**WELWYN HATFIELD COUNCIL – DEVELOPMENT CONTROL**  
**DELEGATED REPORT**

<b>APPLICATION No:</b>	<b>S6/2010/0479/FP</b>
------------------------	------------------------

The proposal is to create an additional hardstanding area to the front and side of the property which is currently landscaped. The proposal would provide additional car parking space for the property. The existing hedgerows which surround the front garden along the northern and eastern extent will remain in place along with a new gravel border running along side the property which will provide drainage from the proposed hardstanding.

Figure 1.0: Existing layout

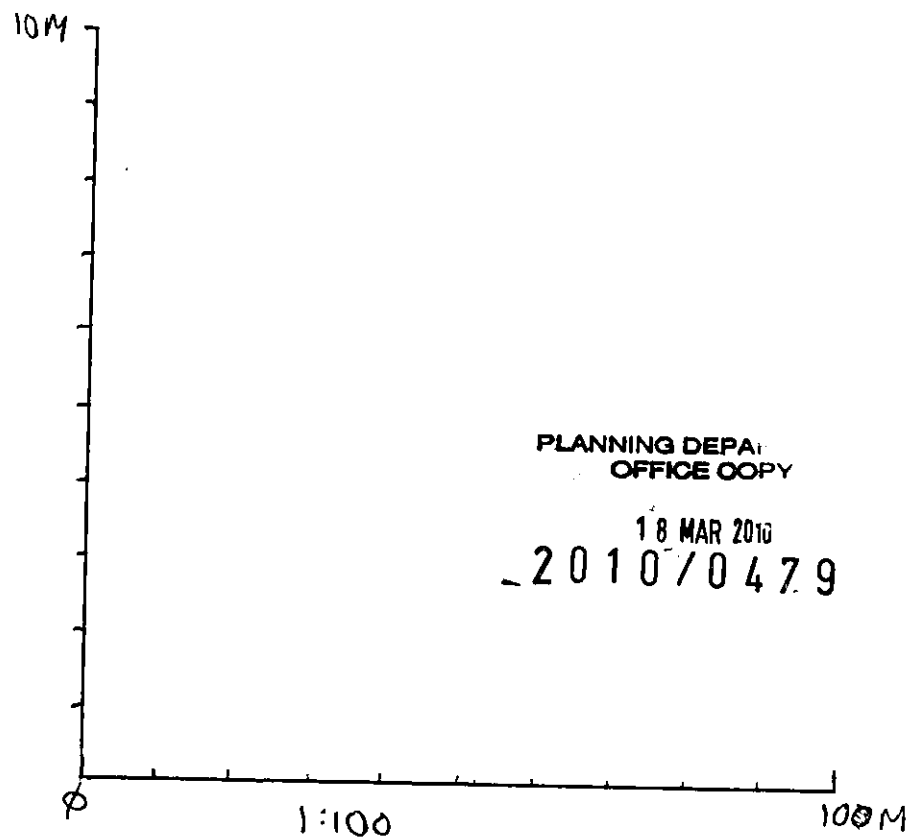
The dwellinghouse is located on a corner plot and it is considered that the existing soft landscaping feature on the corner adjoining No.26 Lavender Close provides a visually important feature within the overall streetscene of the area. Within the residential areas of the Hatfield Aerodrome site are numerous small landscaping areas consisting of both grass verges and hedgerows which contribute to softening the impact of built development within a large housing estate.

No. 26, 28 and 30 Lavender Close share an access onto their individual driveways. All three properties benefit from a small parcel of grassed landscaping to the front of their properties which contributes to softening the impact of hardstanding. In addition, the residential properties in the immediate vicinity of No.26 which sit on corner plots have retained landscaped strips which front onto the highway. Policy D2 states, 'The Council will require all new development to respect and relate to the character and context of the area in which it is proposed. Development proposals should as a minimum maintain, and where possible, should enhance or improve the character of the existing area'. The formation of further hardstanding is not considered to respect the character and context of the surrounding area by reason of the removal of a

REF: DRIVEWAY 1-0

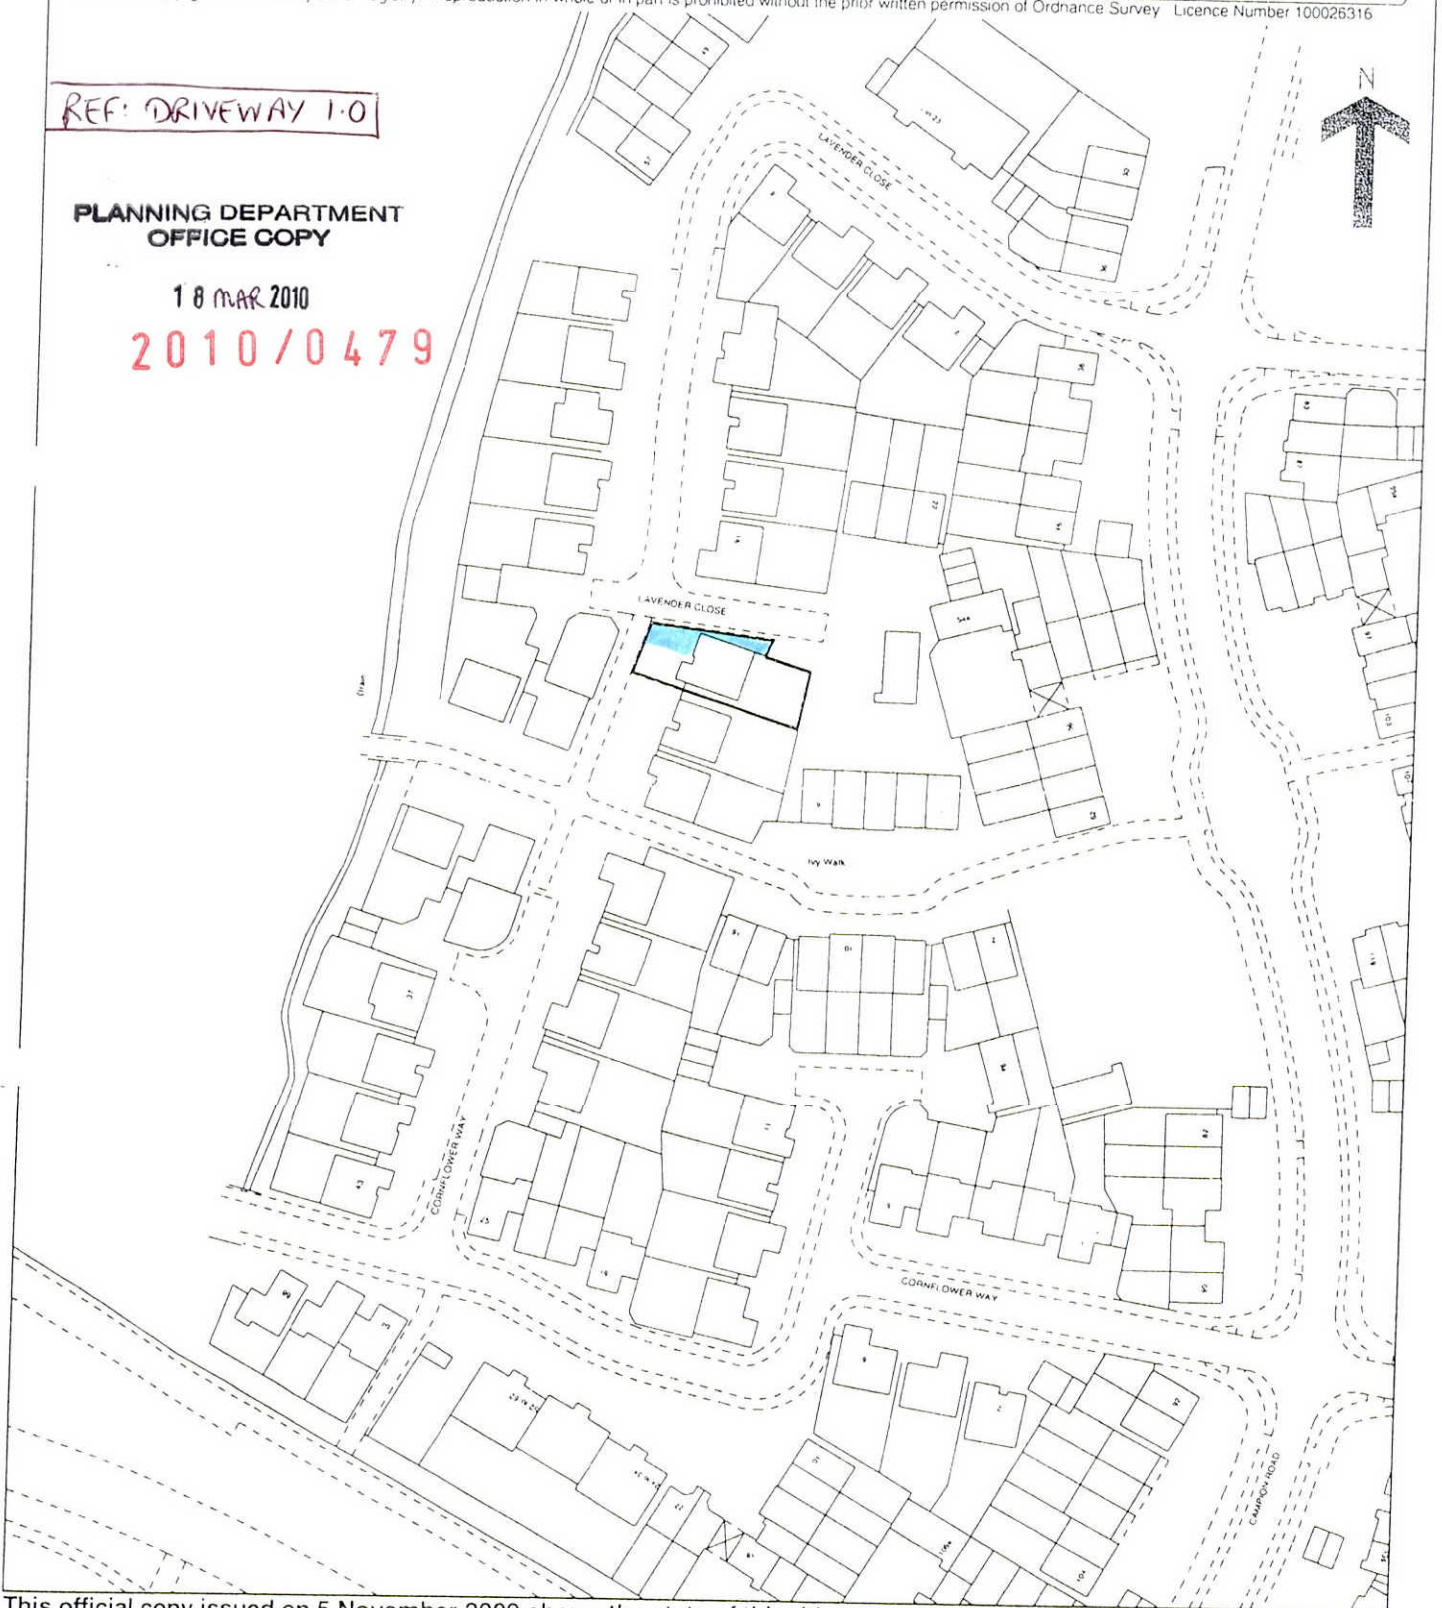
grass verge which contributes to the 'greening' of this housing estate. This is further clarified by supplementary text in relation to policy D2 which states that development should seek to enhance key characteristics which contribute to the landscape and architectural quality.

Taking into consideration the loss of landscaping, the proposal is not considered to maintain or enhance the character of the area and therefore fails to comply with policy D2 of the Welwyn Hatfield District Plan, 2005.

The proposal to remove the soft landscaping feature will result in a detrimental impact on the visual appearance of the streetscene and the general character of the area. As a result, the proposal fails to comply with policy D2 of the Welwyn Hatfield District Plan, 2005.

The proposed formation of hardstanding through the removal of a soft landscaping feature will result in a detrimental impact on the visual appearance of the streetscene. In addition, the proposal is not considered to maintain or enhance the character of the area. The application has therefore failed to comply with Policy D2 of the Welwyn Hatfield District Plan 2005.
